Kirklees Council
Planning and Development Service
PO Box 1720
Huddersfield
HD1 9EL

**Application for Approval of Details Reserved by Condition
Town and Country Planning Act 1990
Planning (Listed Buildings and Conservation Areas) Act 1990**

Discharge of conditions 3 (construction management), 4 (temporary drainage), 5 (temporary waste arrangements), 7 (adoptable roads), 12 (waste storage and collection), 13 (tree protection), 14 (units 23 and 24 revisions), 16 (detailed drainage scheme), 17 (phase II report), 18 (remediation strategy), 23 (materials) and 31 (vegetation removal) of previous permission 2019/91657 for erection of 30 dwellings

Land at Station Road, Skelmanthorpe, Huddersfield, HD8 9BA

Detail
SURFACE WATER MANAGEMENT PLAN

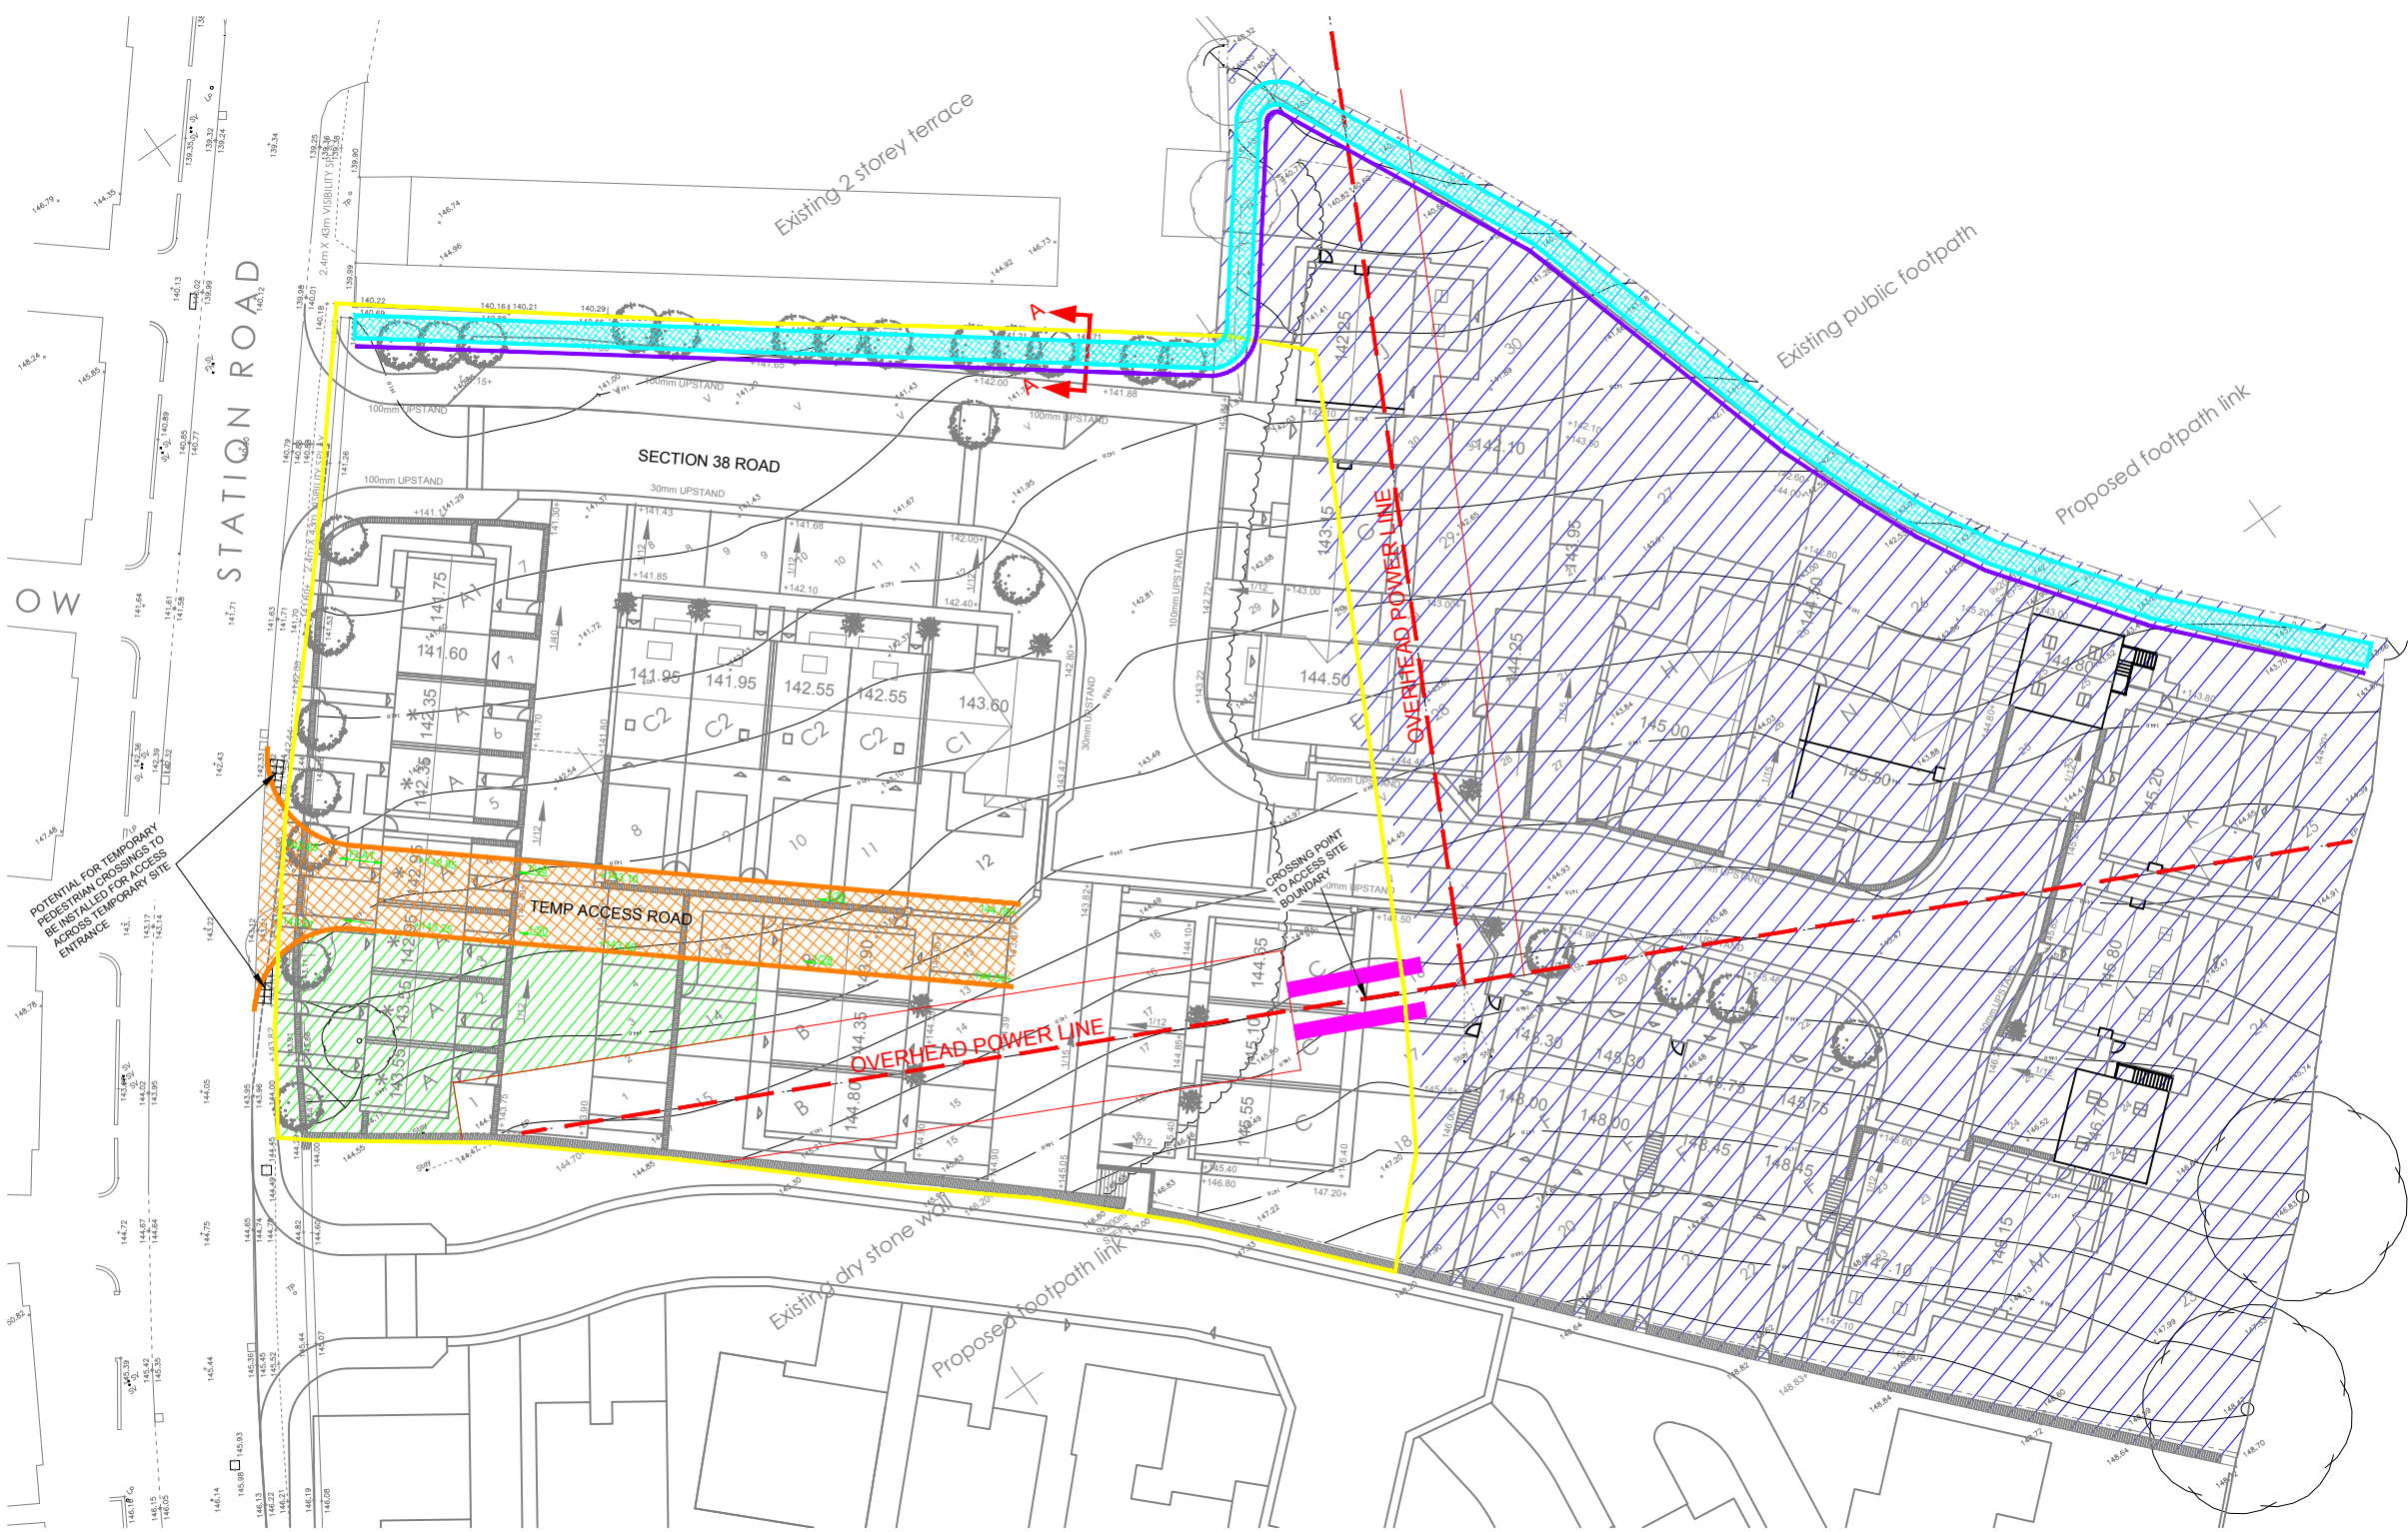
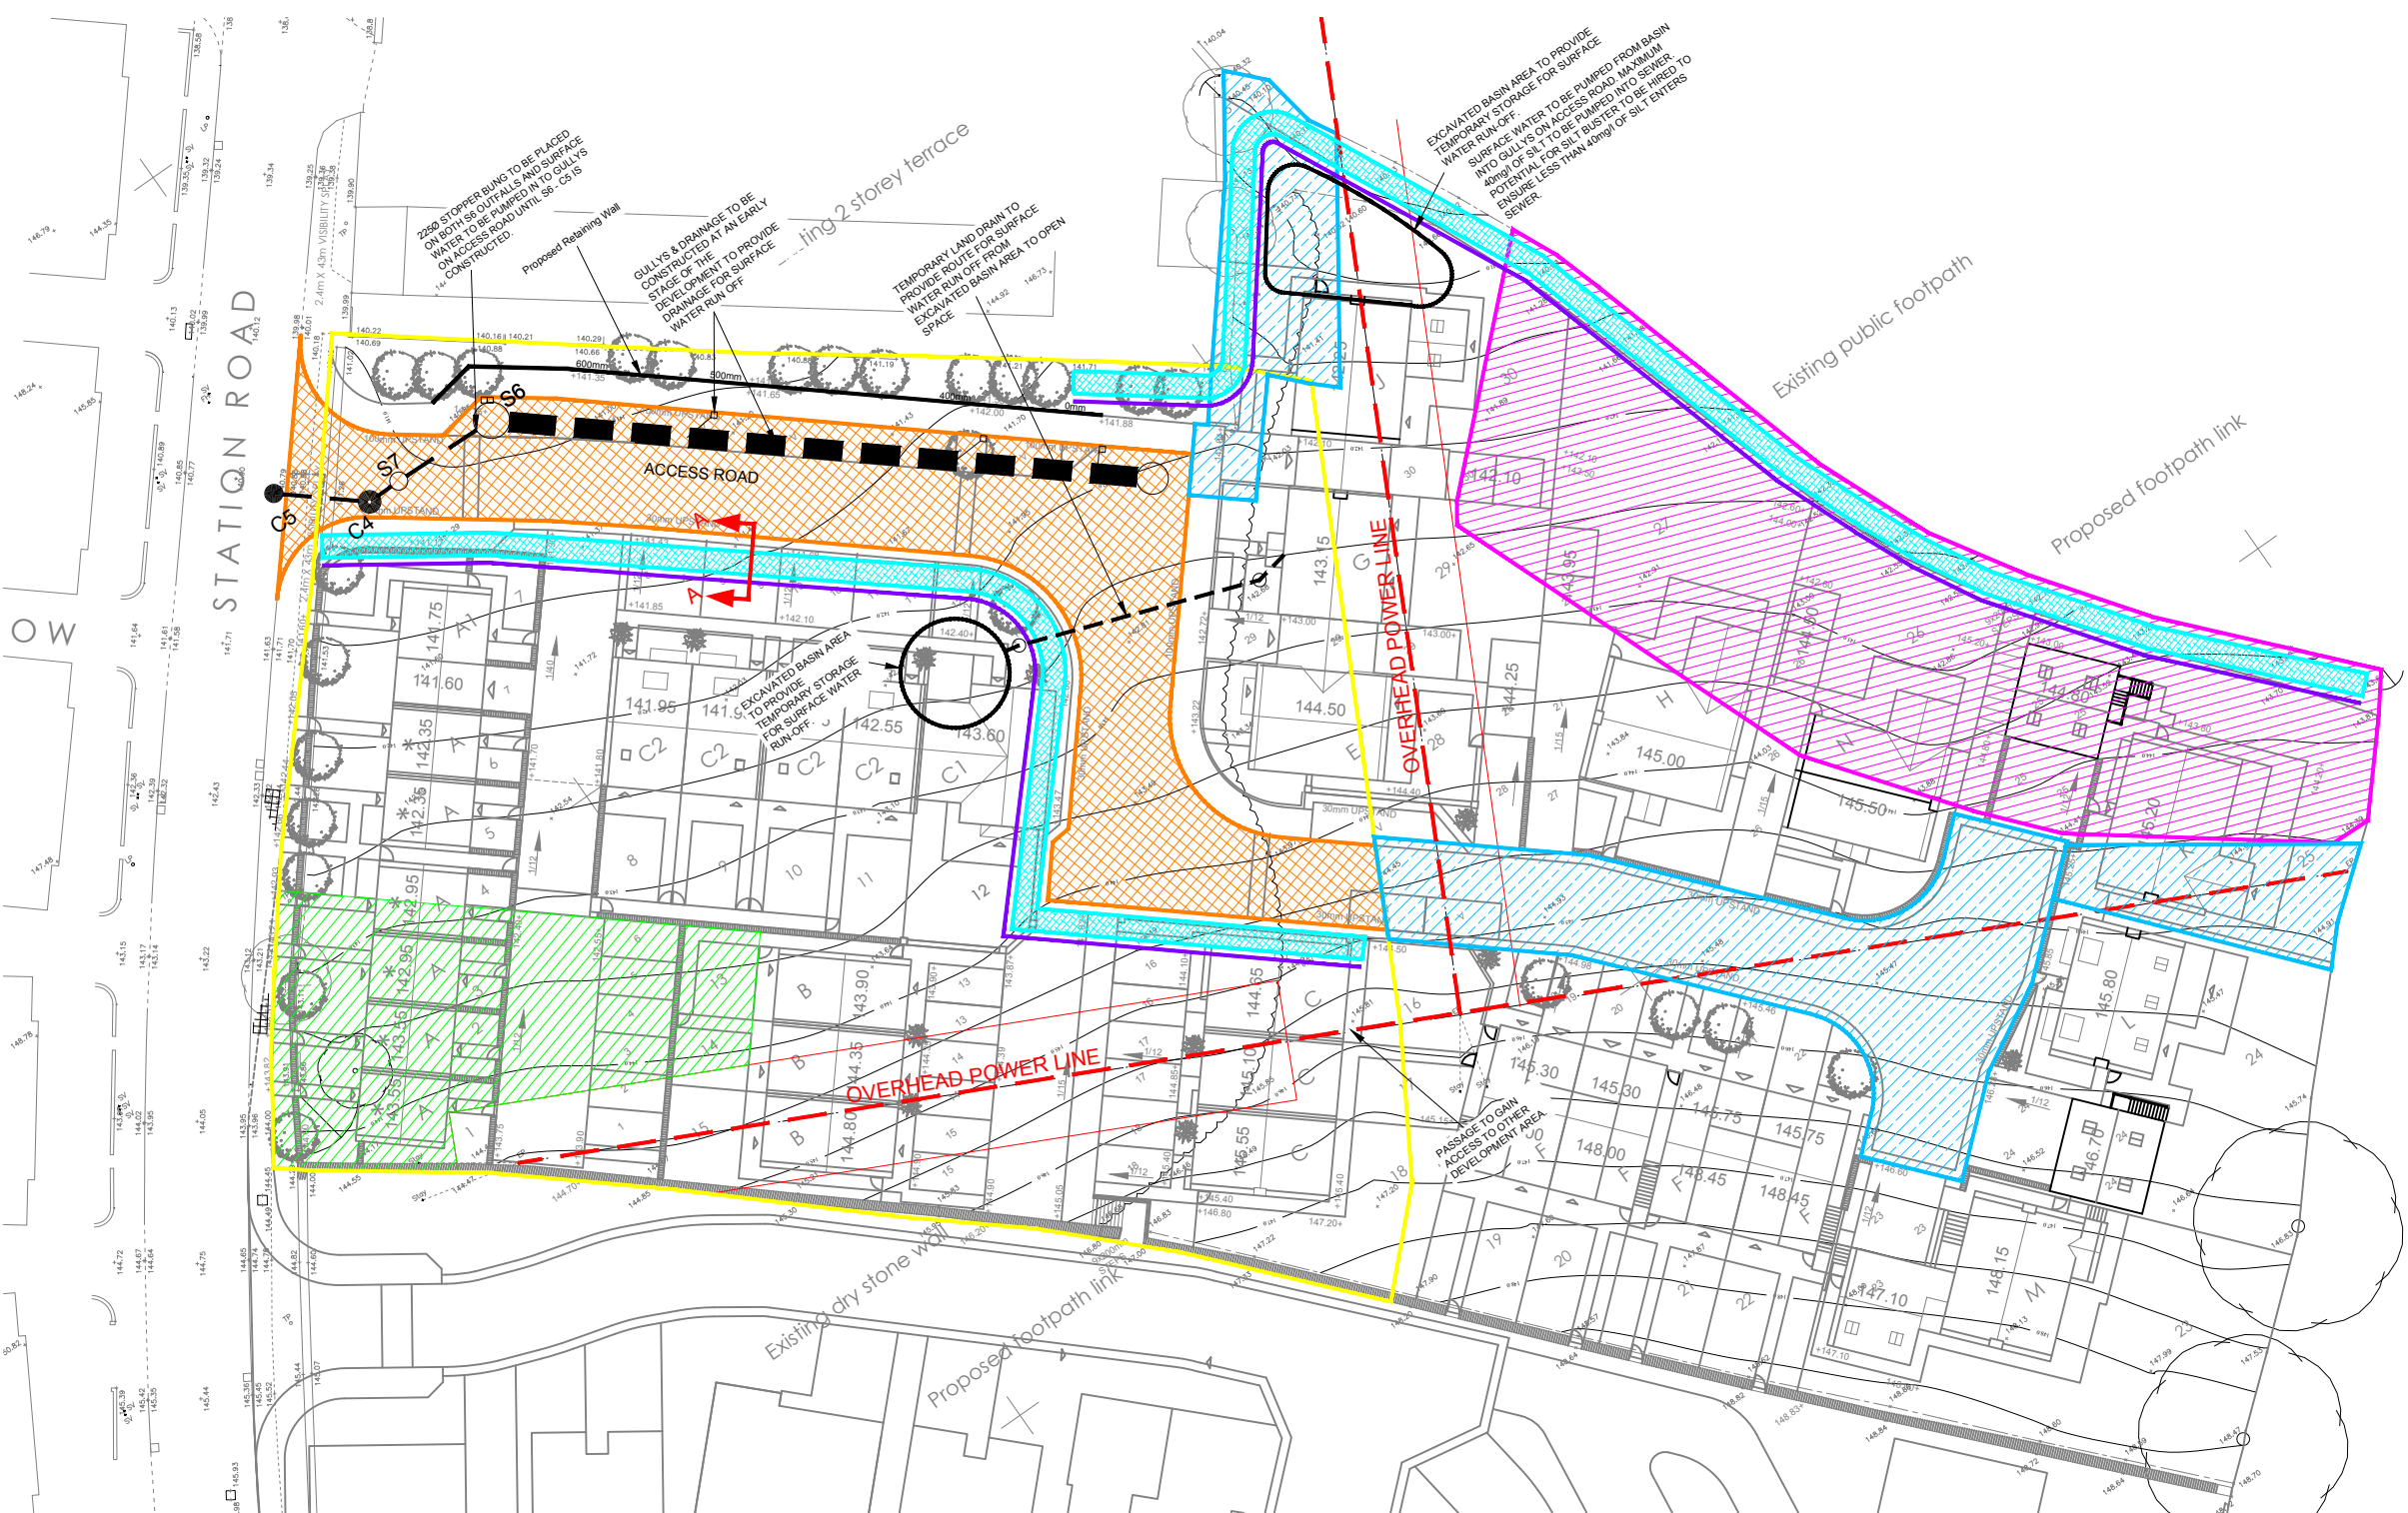
Condition 4 (temporary drainage) – You have submitted a Surface Water Management Plan (drawing E18/7366/042B), a risk assessment (Haigh Huddleston, E18/7366/MH006, 09/08/2021), and a Construction Management Plan (rev B, 01/12/2022). On 02/12/2022 you confirmed (by email, with photographs) that two witches hats had been installed in Station Road.

Details set out in the above-listed documents, drawing, email and photographs are considered acceptable for the purpose of condition 4, and are hereby approved.
